Planning and Urban Development Department

Subject: IOZ Design Review – 22 Bramhall (Maine Medical)
Written by: Caitlin Cameron, Urban Designer
Date of Review: Friday, March 16, 2018

This memo summarizes the applicable design guidelines and staff review for the projects at 22 Bramhall Street – East Tower and Visitor Garage expansion. These two projects are reviewed according to the adopted IOZ IDP and Regulatory Framework standards.

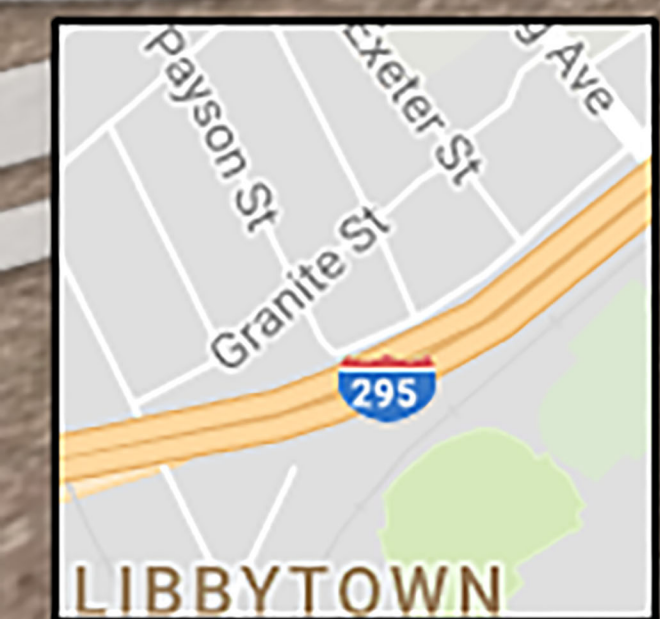
East Tower: **Planning Board generally found that the proposal is cohesive with the future vision as presented in the 2/27 materials.** The applicant provided a view from I-295 that further demonstrates the intent for the East Tower expansion to visually contribute to the planned new character of the campus. The white material selection is intended to be a cohesive element throughout the campus moving forward.

NORTH ELEVATION

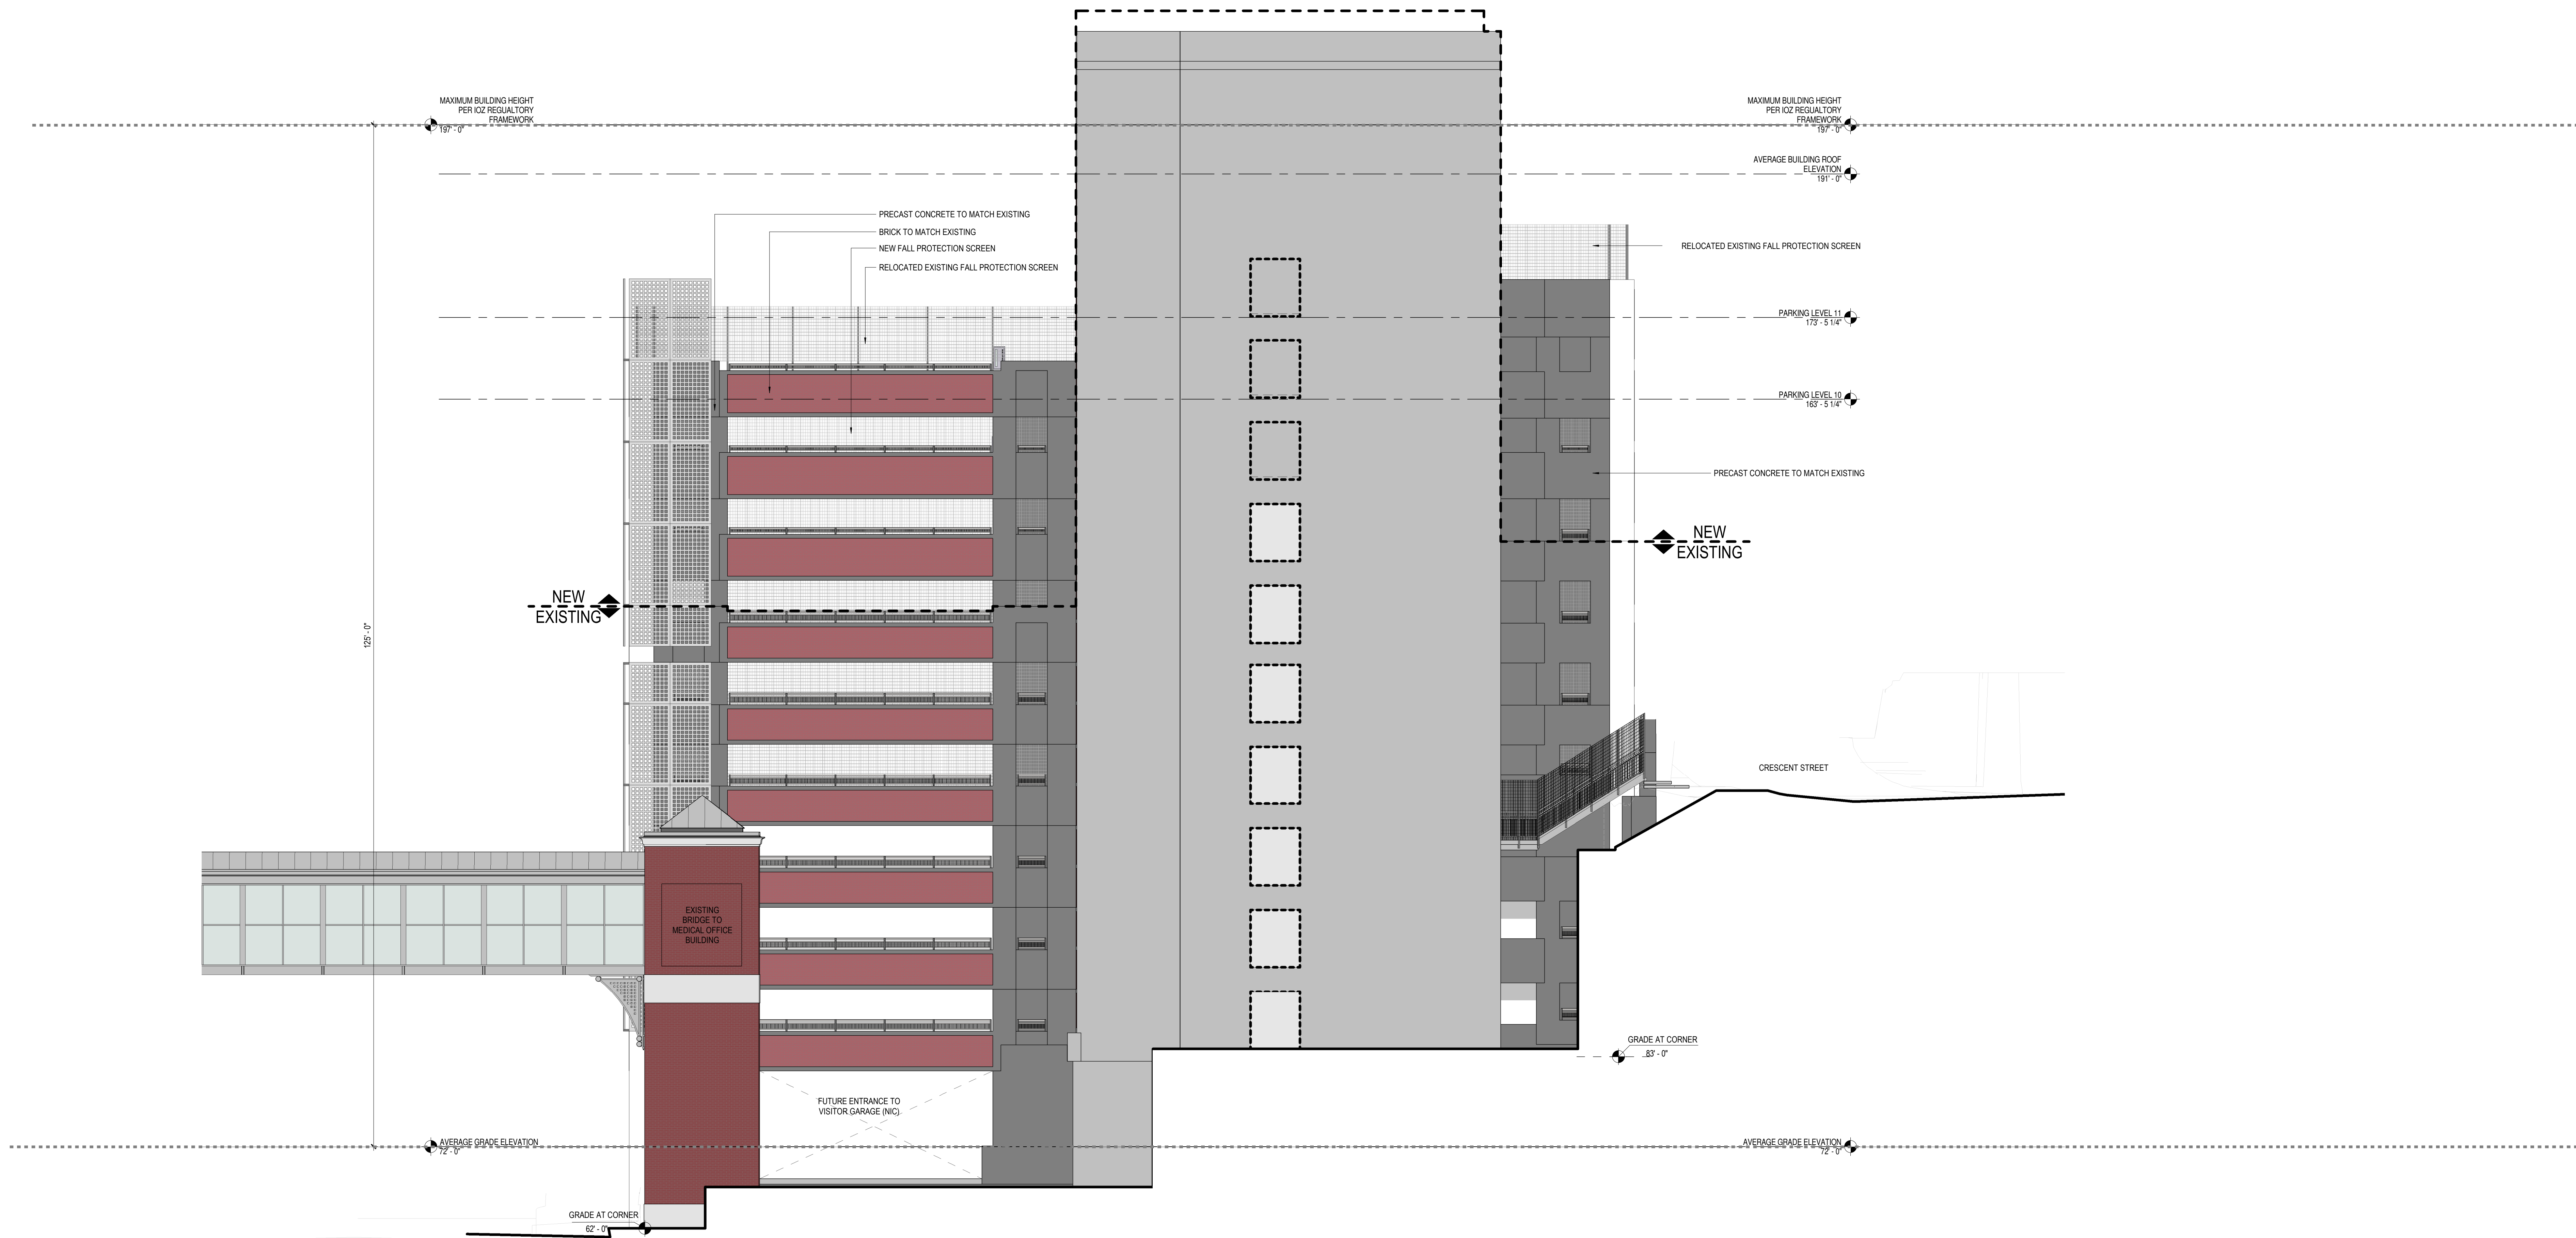
Visitor Garage: The proposal maintains the existing material palette of brick, concrete, and metal screen. **Planning Board is concerned about the prominence of the garage on Congress Street and the lack of visual interest and contribution to the public realm by using the existing material palette.** In response to the Planning Board's comments, the applicant revised the elevation to extend the screens above the top deck adding visual interest to the roofline, screening the fall protection. There is a gap between the existing screen and the new screen to add some visual relief and to differentiate the existing from new façade. These screens will wrap around the corners of the building.

Visitor Garage: **Congress Street is a major street and this building will become even more visible from long views as it grows in height. The garage proposal lacks visual interest from long views – articulation and visual interest are important for the garage in the forefront of the campus. Planning Board asks that the applicant re-evaluate the approach. The roofline is an element where visual interest could be added - Planning Board commented that the simple roof form does not have enough visual interest for the long views.** The applicant revised the screens in response to these comments. The screens will extend higher to provide a varied roofline that also screens the fall protection fence. The screening will wrap around the corners. There will be a reveal between the existing and new screens to give a visual break, as well as a literally break between the existing and new construction. These elements address the Board comments by adding some dynamic elements to the roofline in a way that is structurally feasible.

Visitor Garage: The architectural character remains largely the same as the existing condition and is found to be consistent with the established character. The building addition increases the visibility of the campus from those long views. The applicant revised the screens to extend above the top deck, addressing the comments about the visual interest of the roofline.

Visitor Garage: The massing, roof forms, rhythms, and material relationships remain mostly unchanged from the existing conditions. The screens will be extended up and around the sides of the building to further address the desire to for visually interesting roof lines.
